Sea Link

Document: 6.15 Scoping Opinion 2022

SCOPING OPINION:

01 December 2022

Scheme: SEA LINK  
 Document Title: STATUTORY DESIGNATED ECOLOGICAL FEATURES - SHEET 1 OF 5

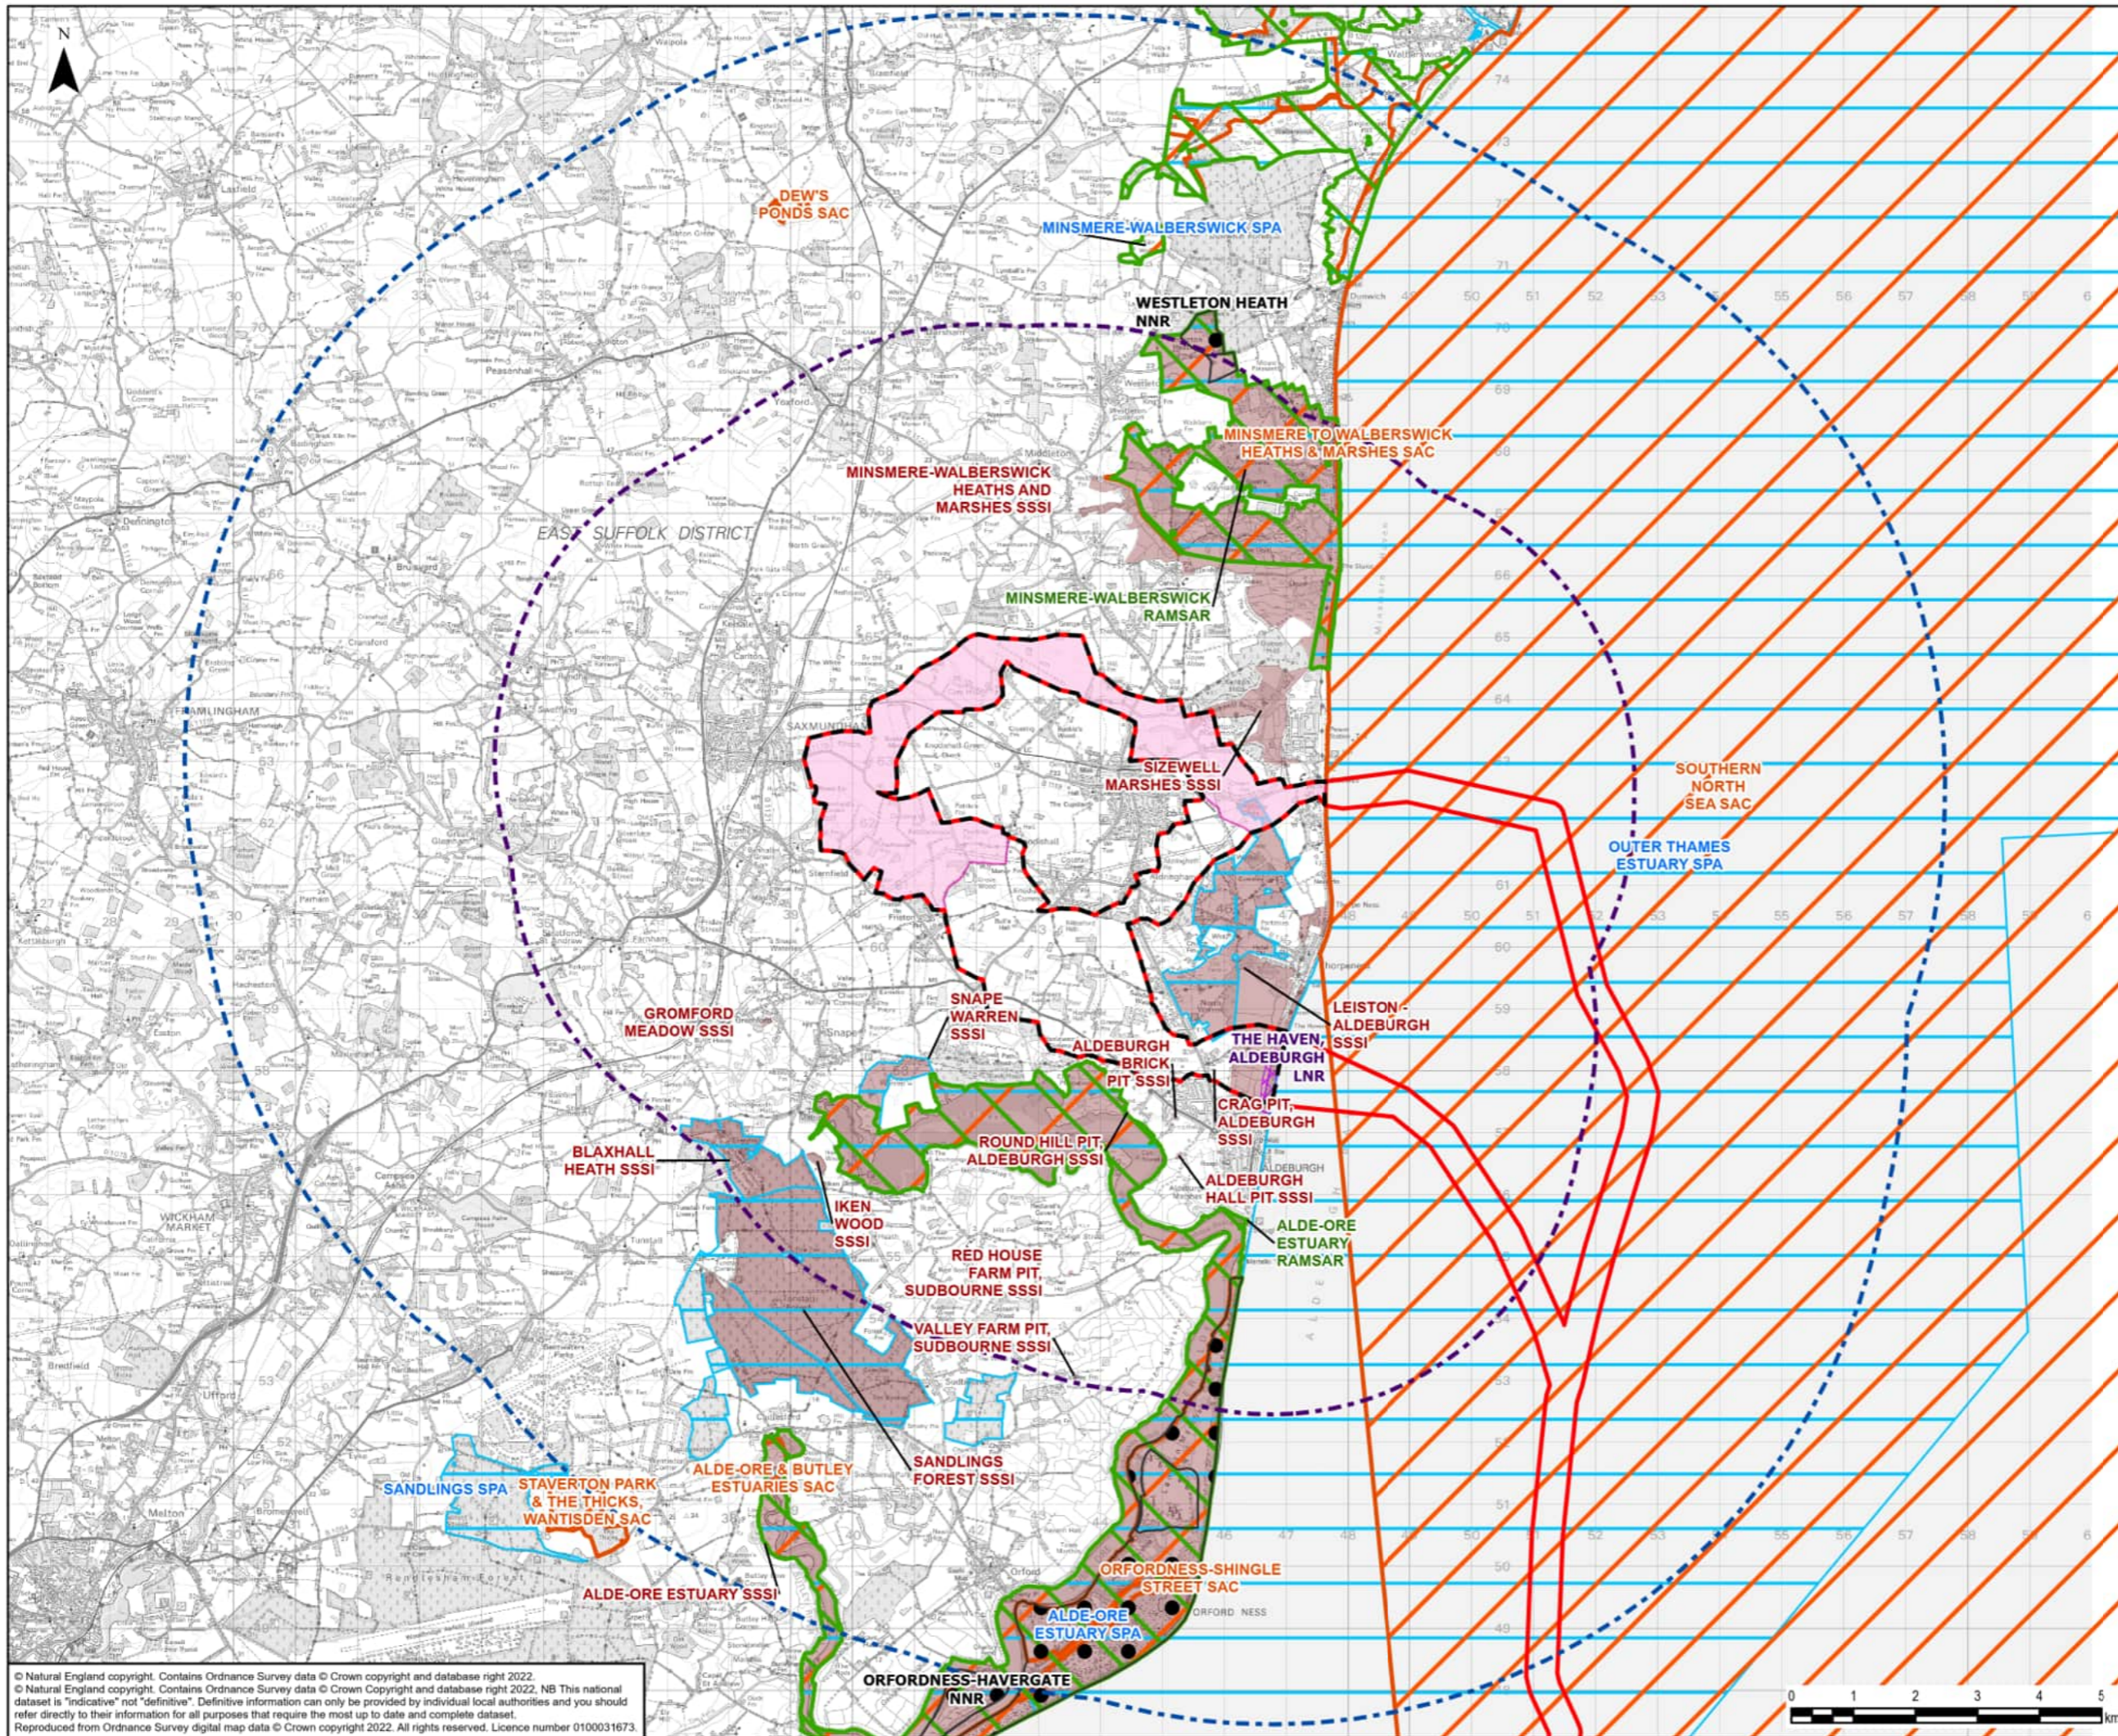
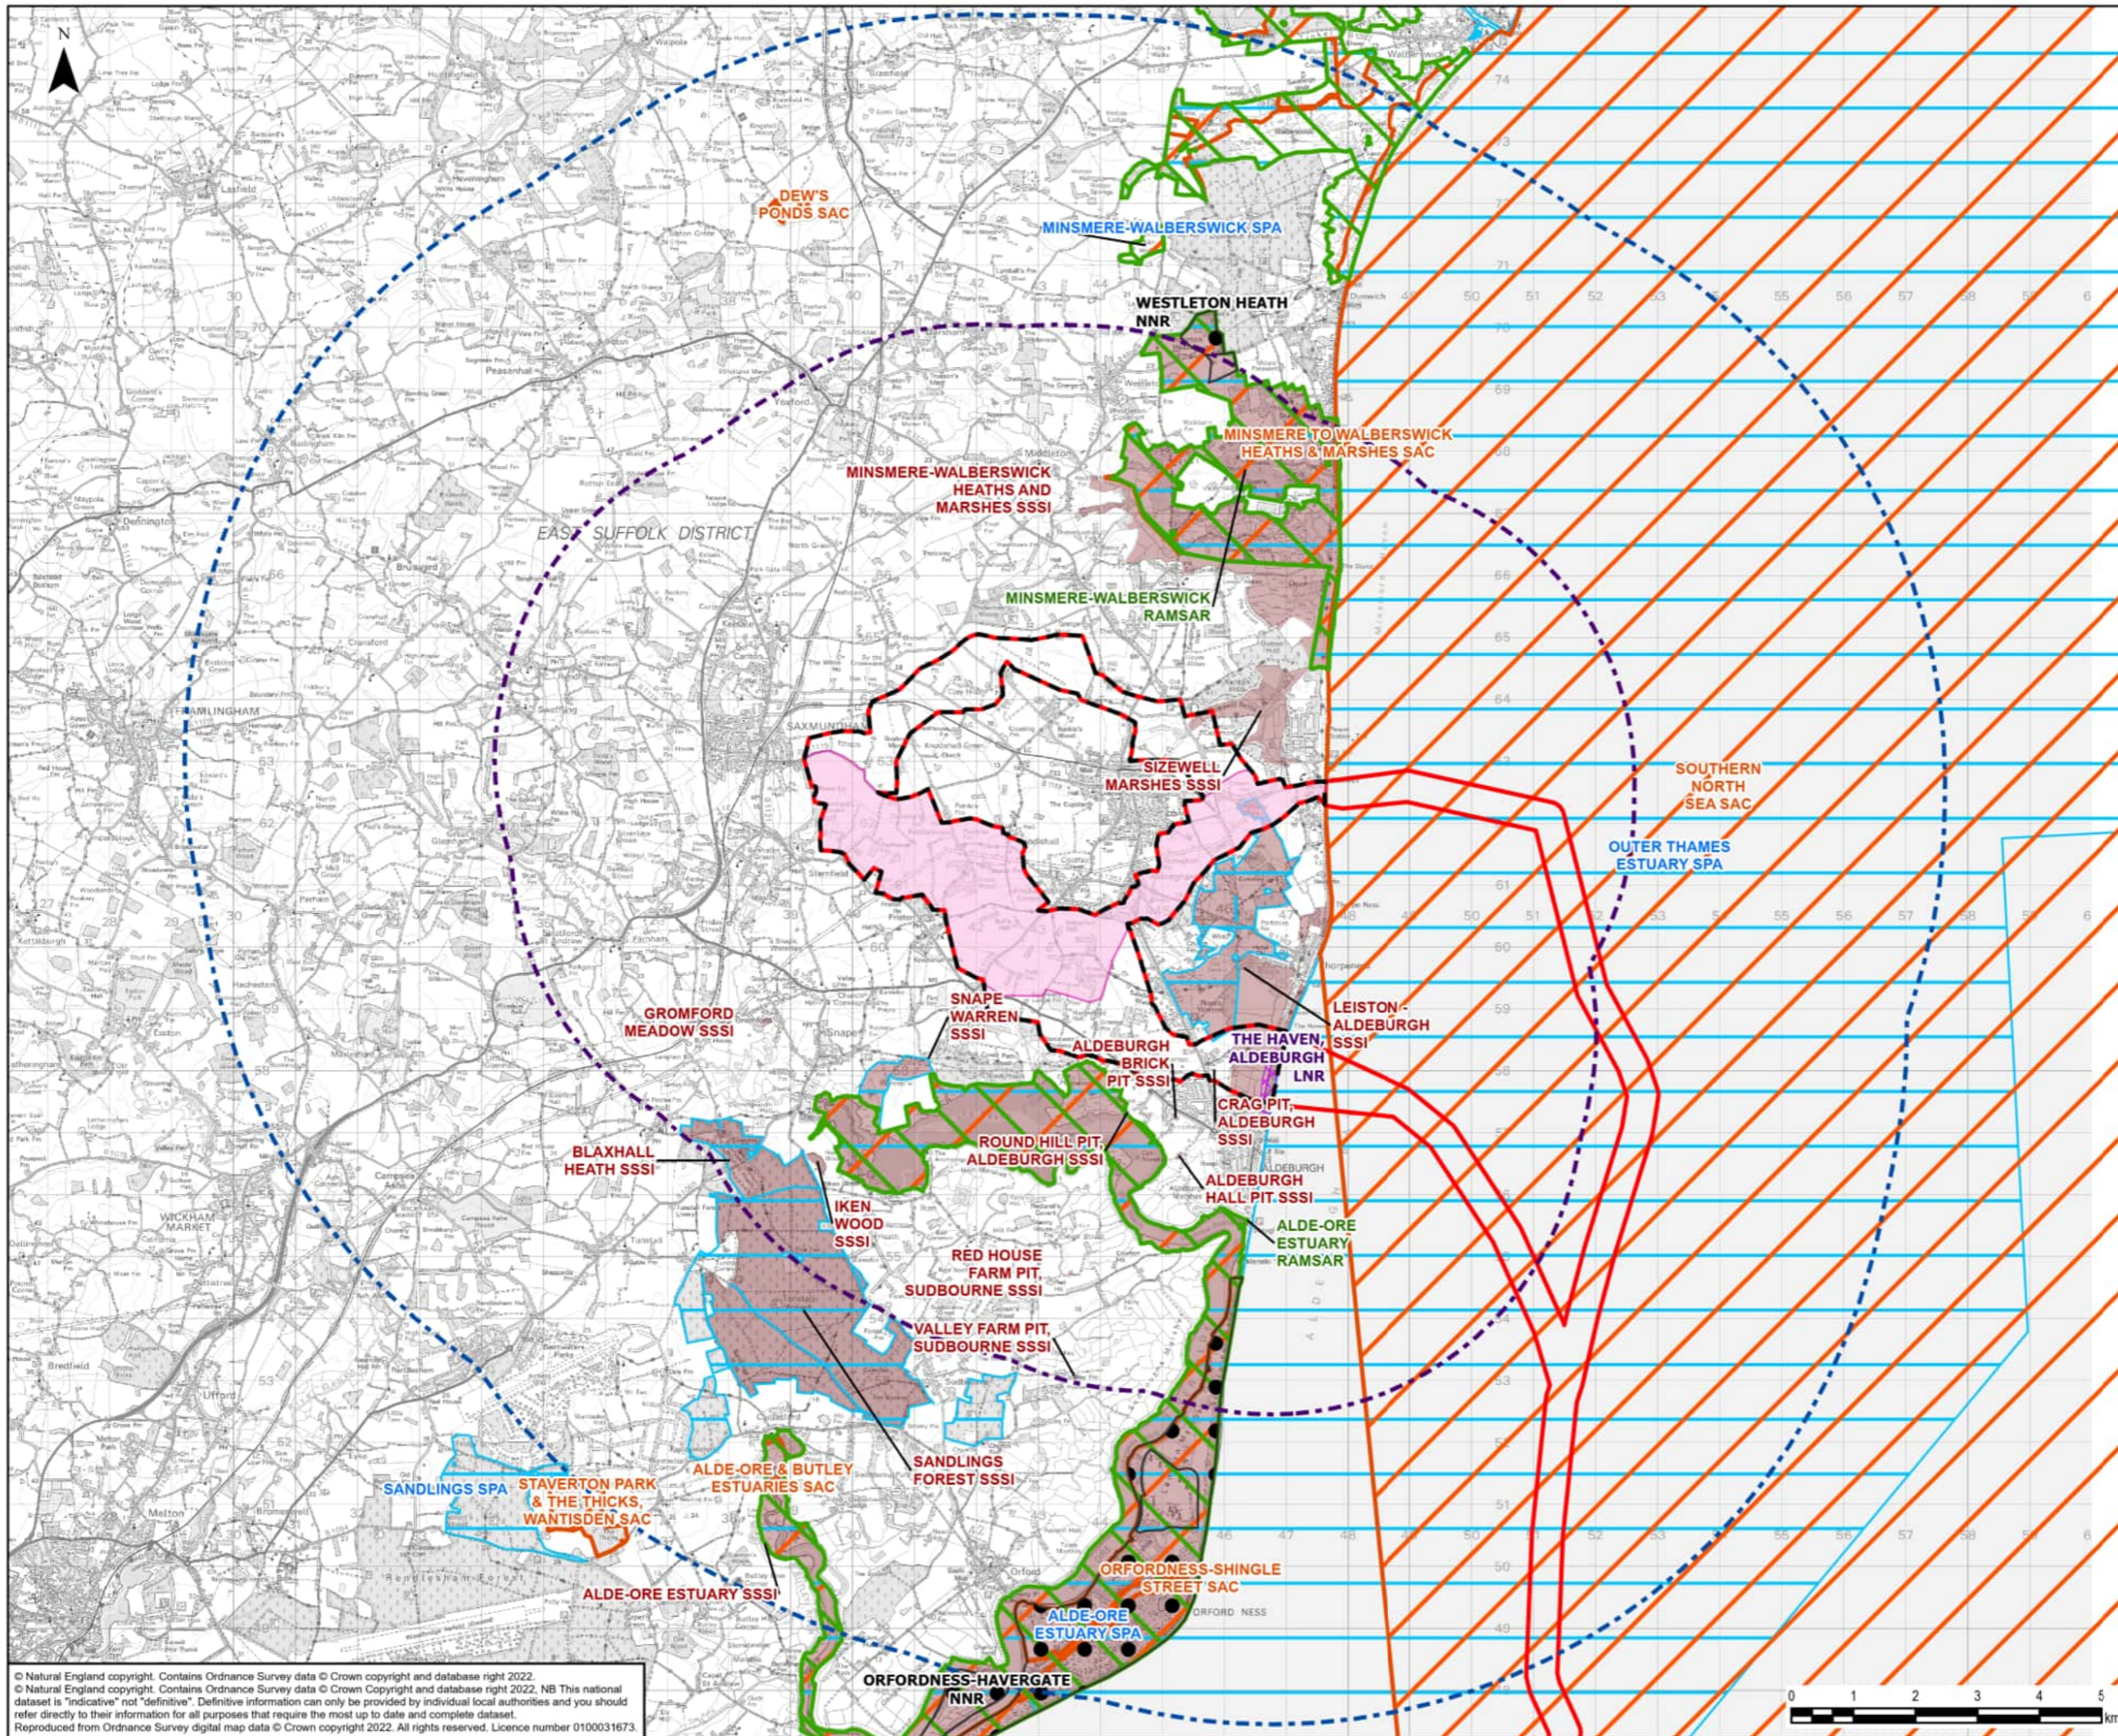
ID	Ref	Description	Inspectorate's comments
3.2.2	Volume 3, Figure 2.3.1	Figures	The location and extent of Sandlings SPA is not clear from Figure 2.3.1. Figures accompanying ES should clearly show and label the location and extent of designated sites.
